Mr Andrew Lewis
Planning Officer
Cherwell District Council
Bodicote House
Bodicote
Banbury, Oxfordshire
OX15 4AA

04th June 2020

Response to Planning Application Amendments to 18/00825/HYBRID

WALKING AND CYCLING STRATEGY

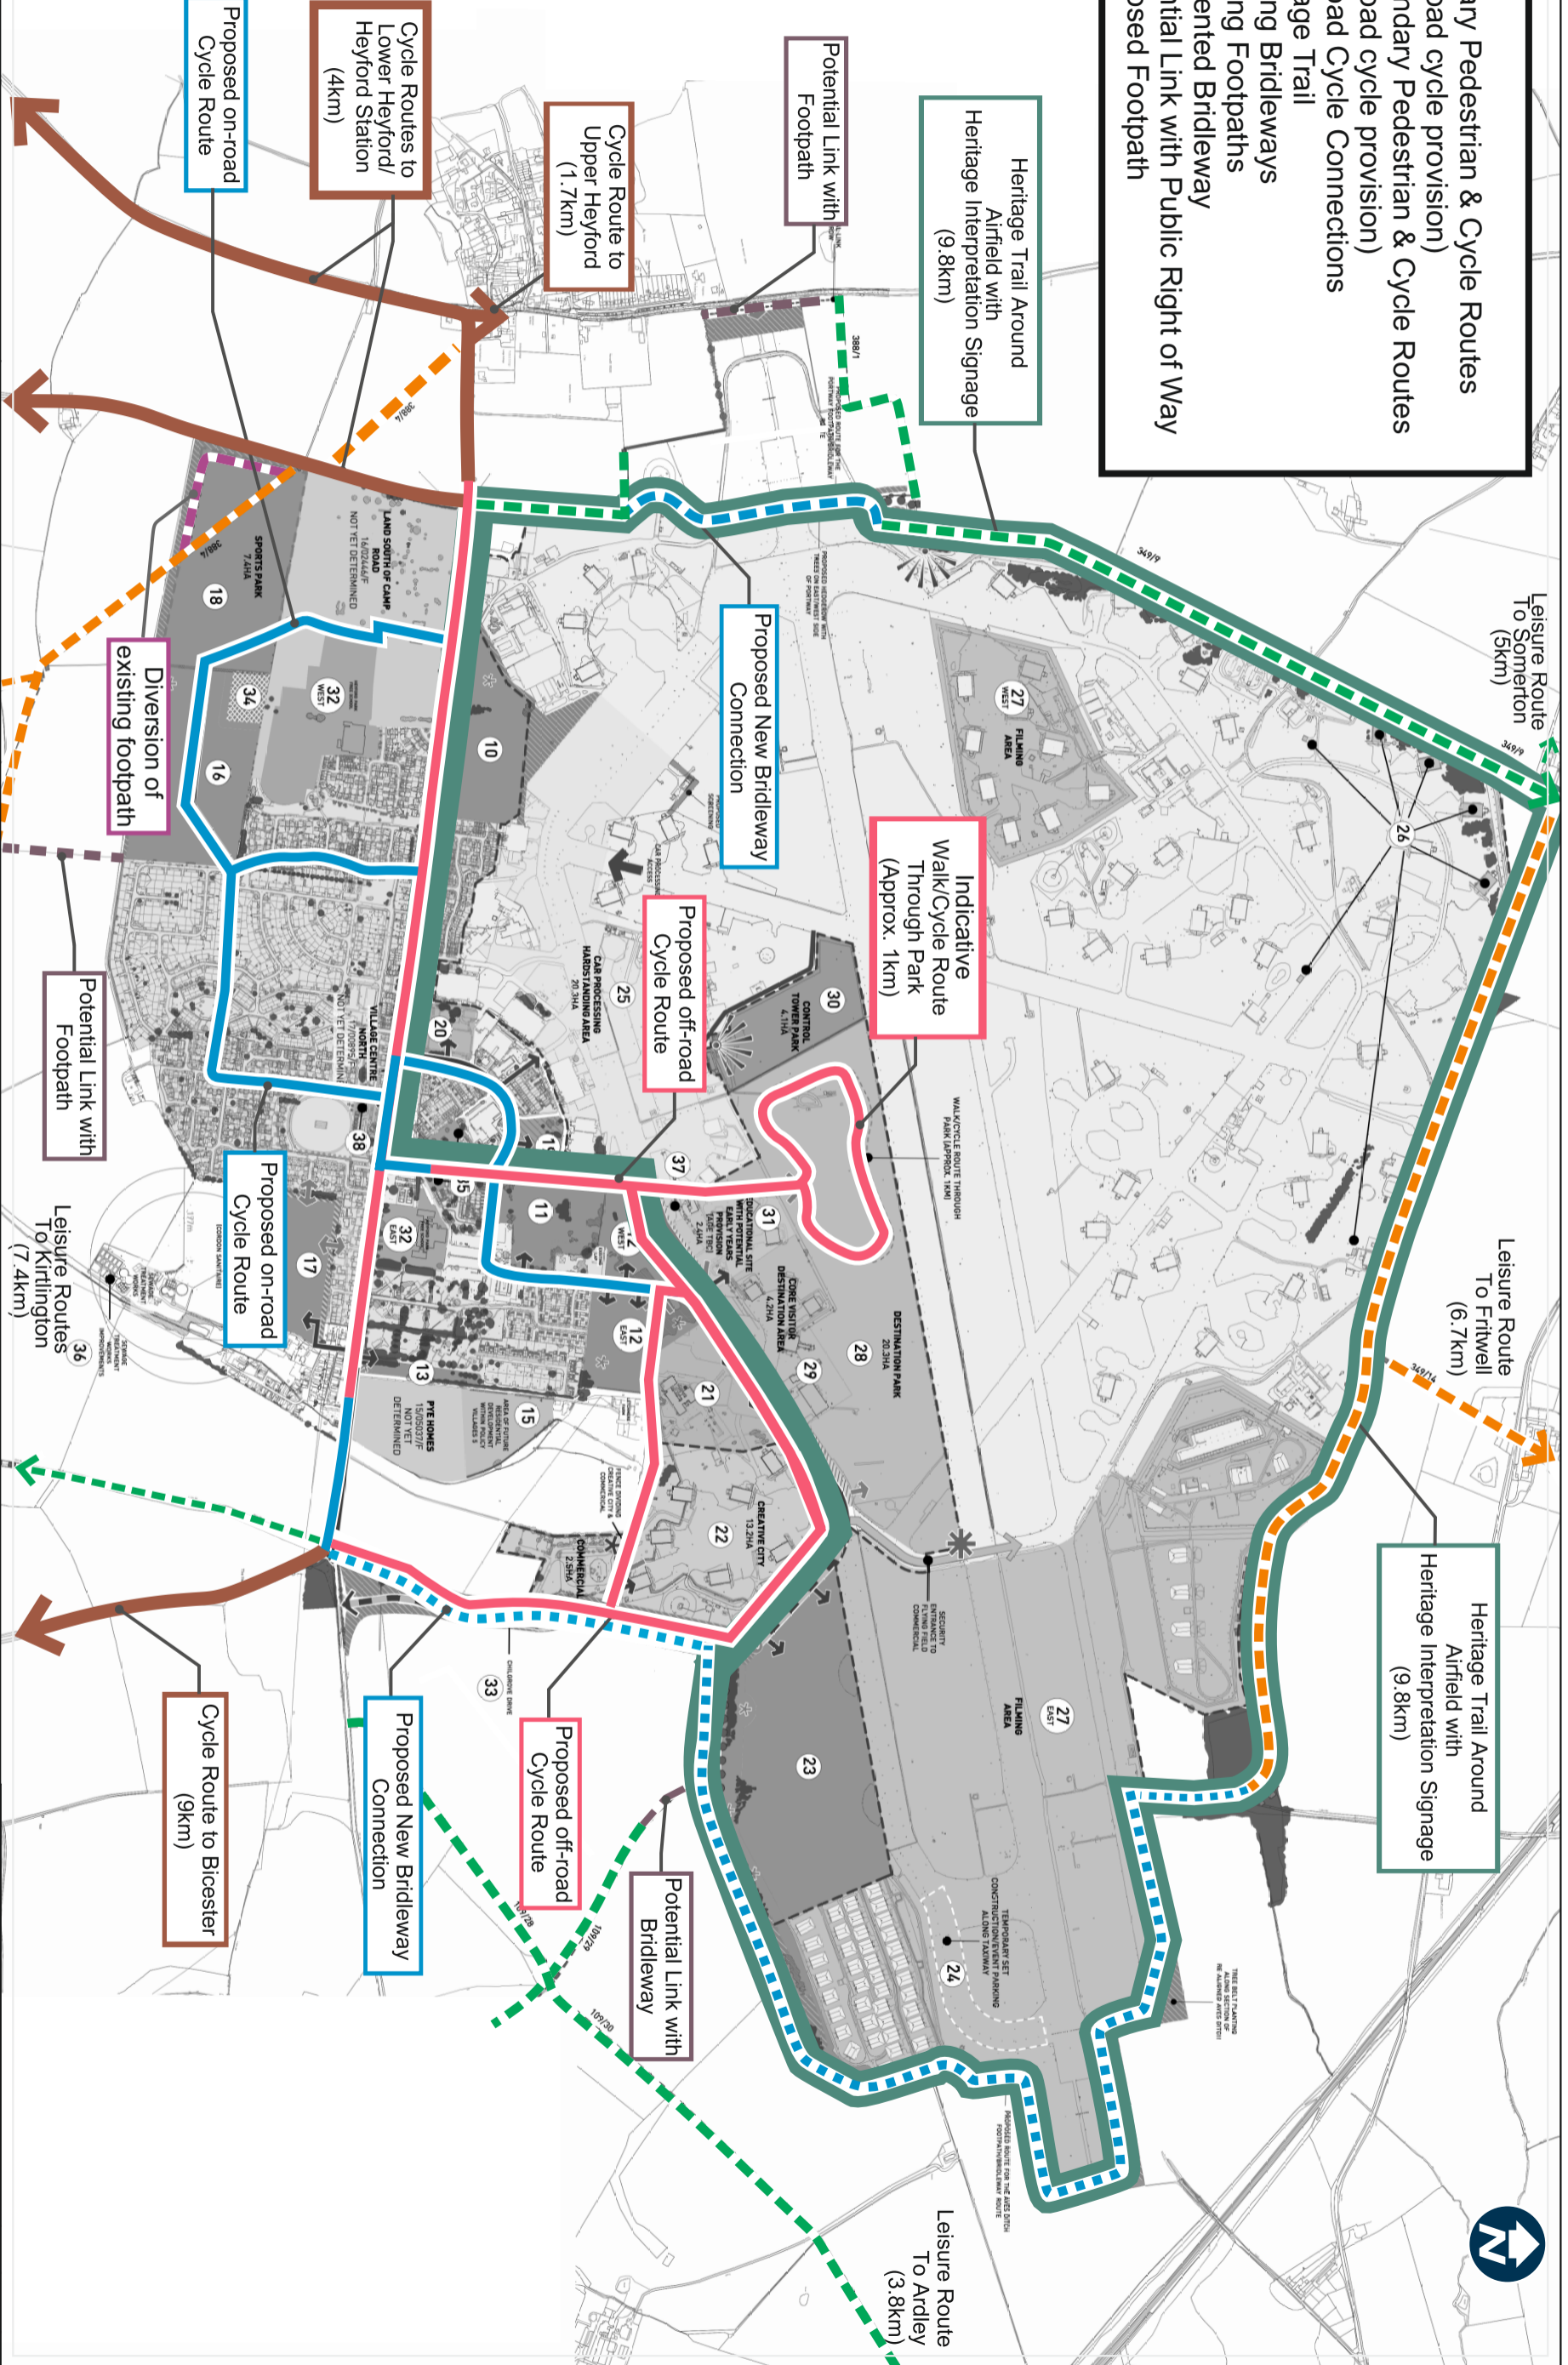
b) The proposed cycle routes between Heyford Park and Bicester are unsuitable for use by families as there is no buffer zone between them and the busy roads that service this area.

Any new cycle paths should be installed away from the roads so that there is a distinct demarcation between the two areas e.g. in the form of a verge.
